CITIZEN ON CONSTITUTION FINAL PLAT

LETTER OF INTENT

APRIL 11, 2022
KIMLEY-HORN AND ASSOCIATES

FINAL PLAT

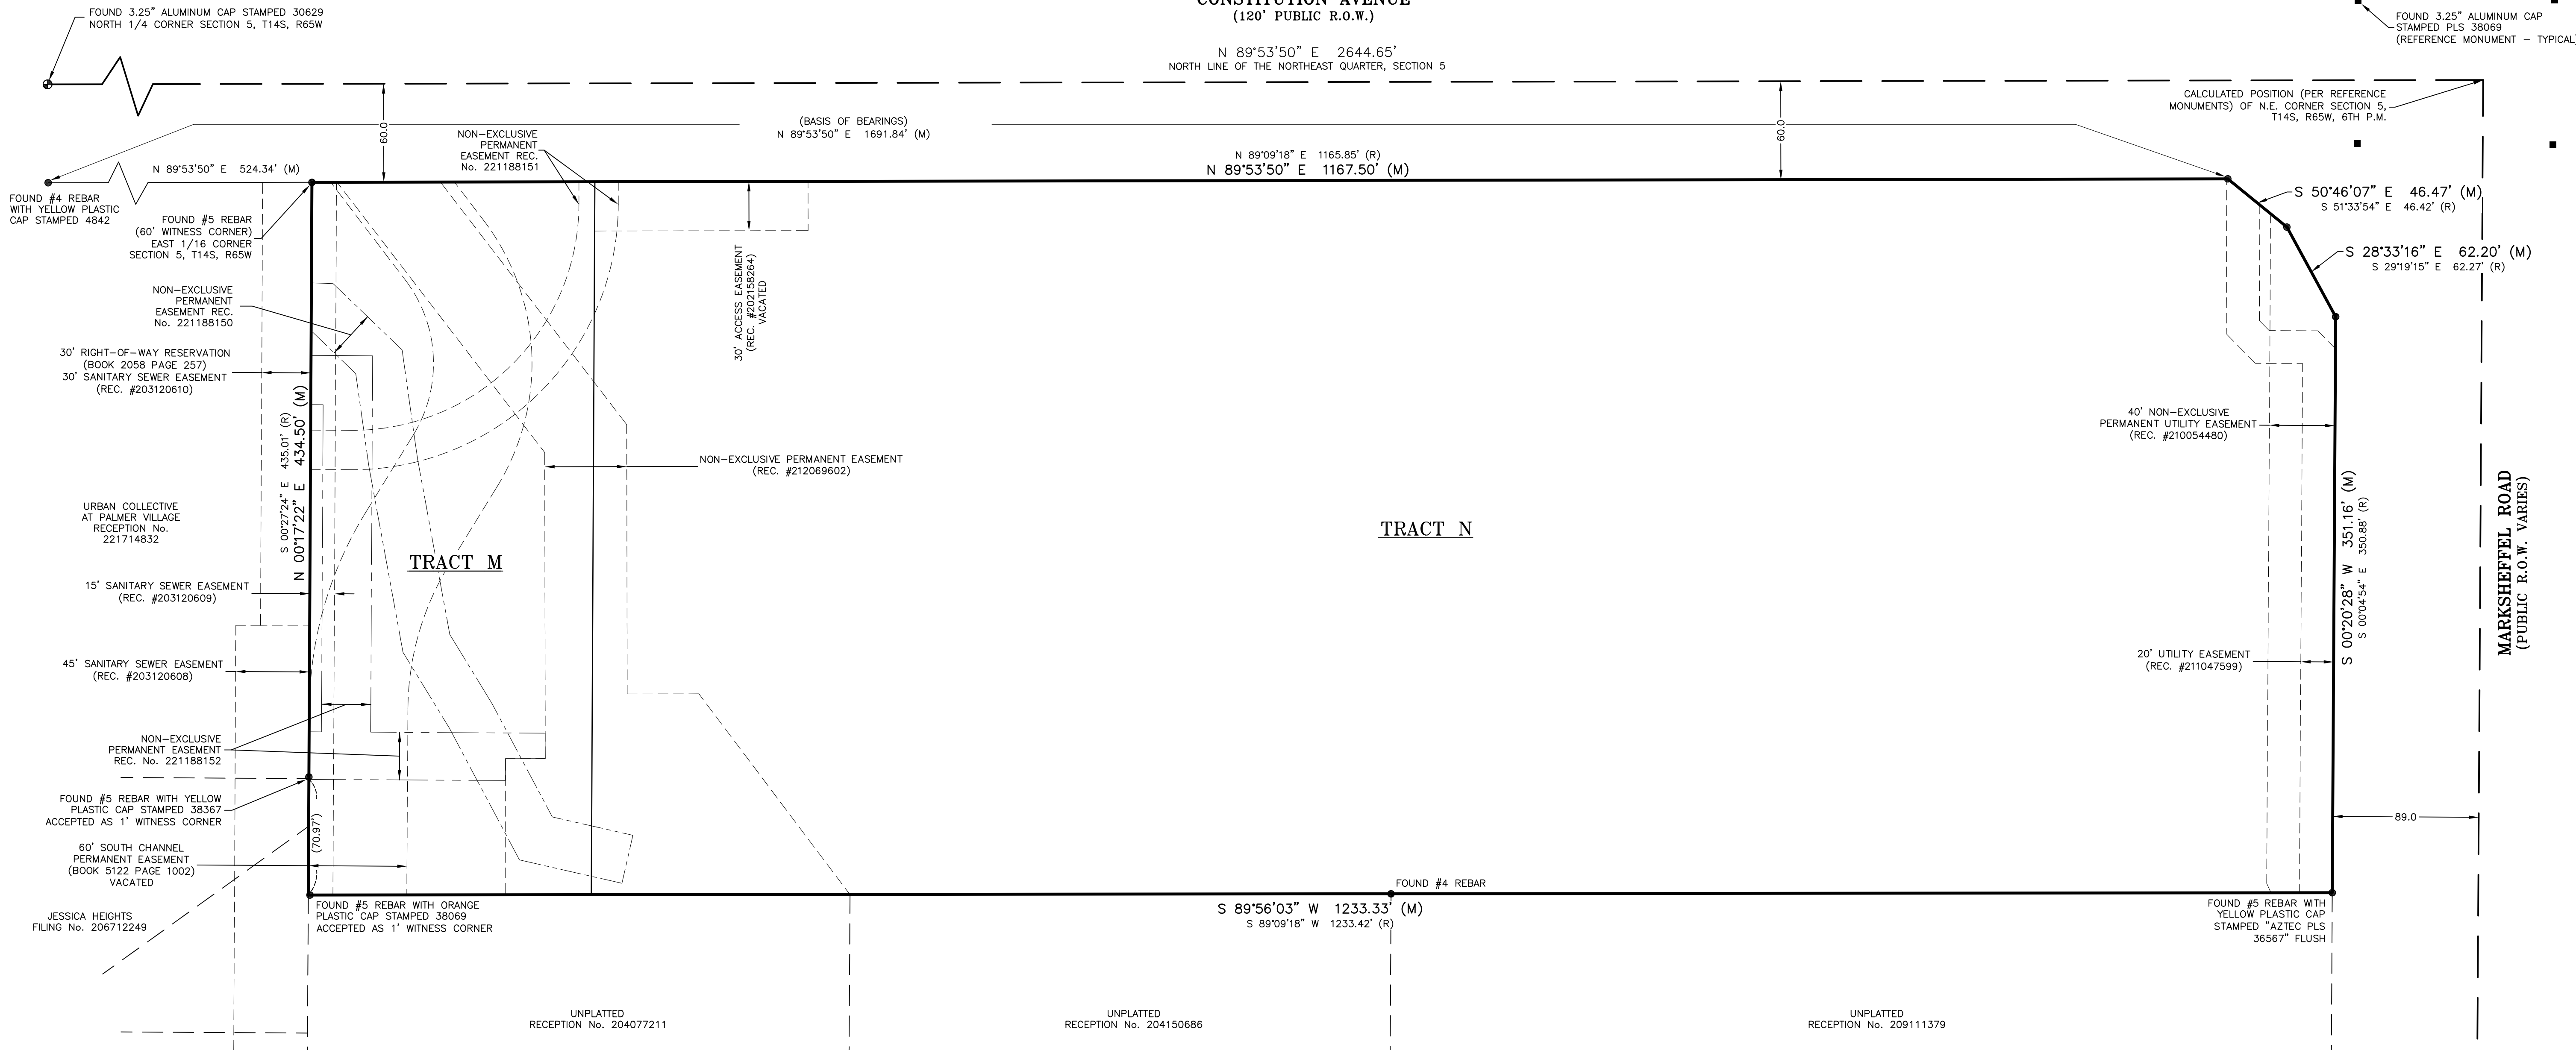
This is not shown on the plat. Revise accordingly.

repeat comment depict on the plat

Repeat comment. You are mitigating the noise by agreeing to noise mitigation construction practices (extra insulation, triple pain window?) because the noise exceeds 66bd - plat note should state this is required. a new contractor could come in and not build the same that this one does if this builder should cease.
